**From:** Abiel X. Carrillo  
**Sent:** Thursday, May 05, 2016 4:09 PM  
**To:** 'David Soule'  
**Subject:** RE: H10D006B - ABQ Boat and RV

**RE: Albuquerque Boat & RV Storage  
Grading and Drainage Plan  
Engineer's Stamp Date -- 4-15-16  
Hydrology File: H10D006B**

Based upon the information provided in your submittal received 4-15-2016, the above referenced Grading and Drainage Plan is approved for Site Plan for Building Permit, Building Permit, and Grading Permit.

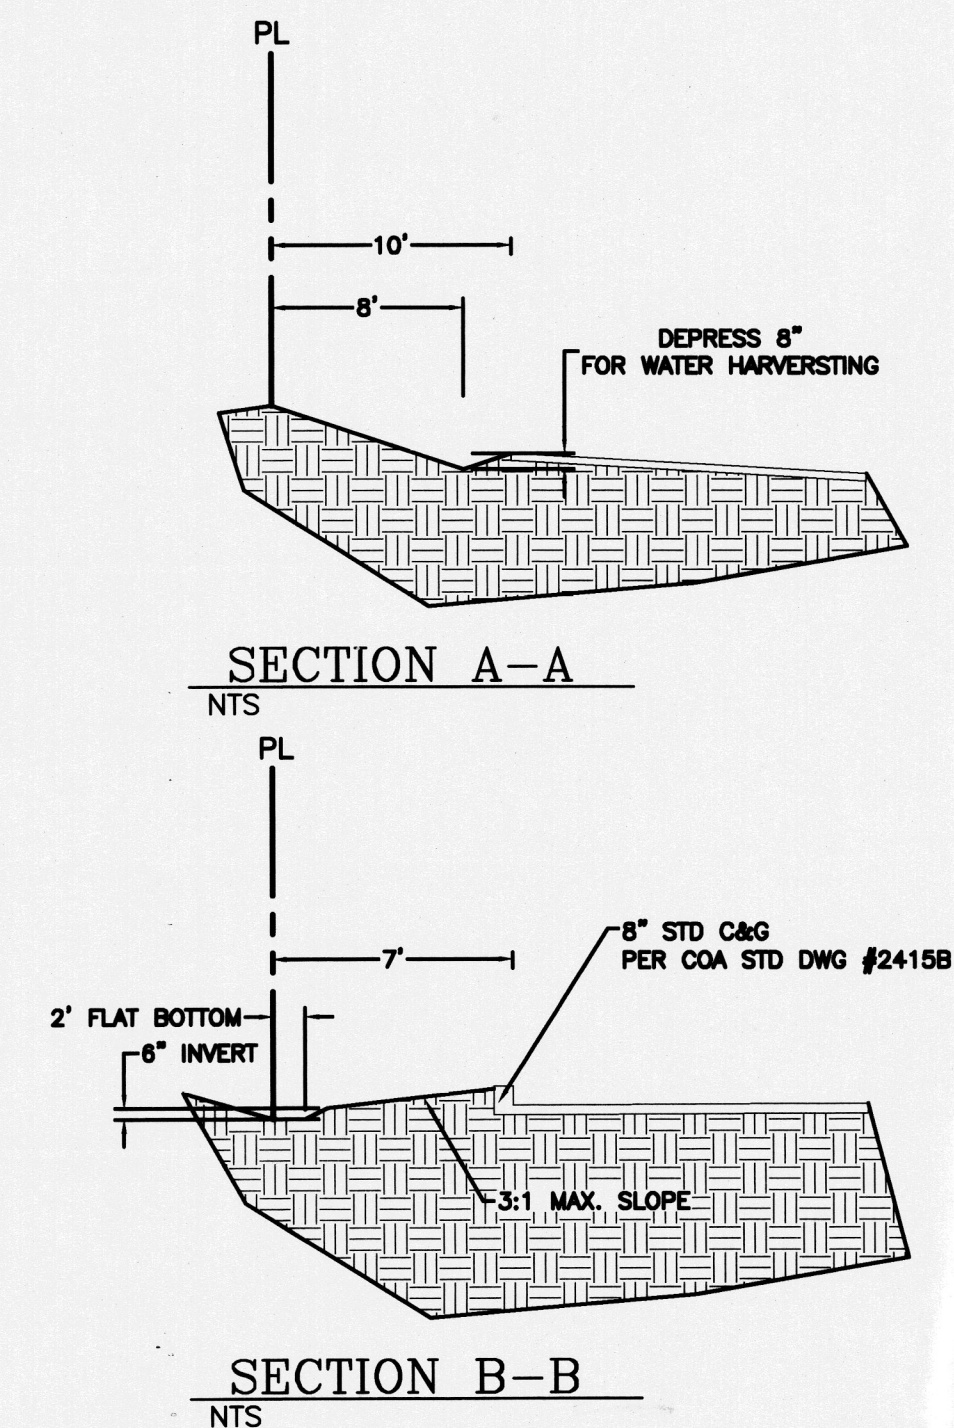
You will notice that I did put a condition for CO, which is to make sure during construction that all flows are directed to the driveways. Your report makes it clear, but there seems to be a gap between the wall and the curb on the southern entrance. Figured that is easier than to re-submit just for that.

1. All flows to La Morada must be routed through the driveways as stated in the Drainage Report. If substantial flows are overtopping the sidewalk, a sidewalk culvert will be required.
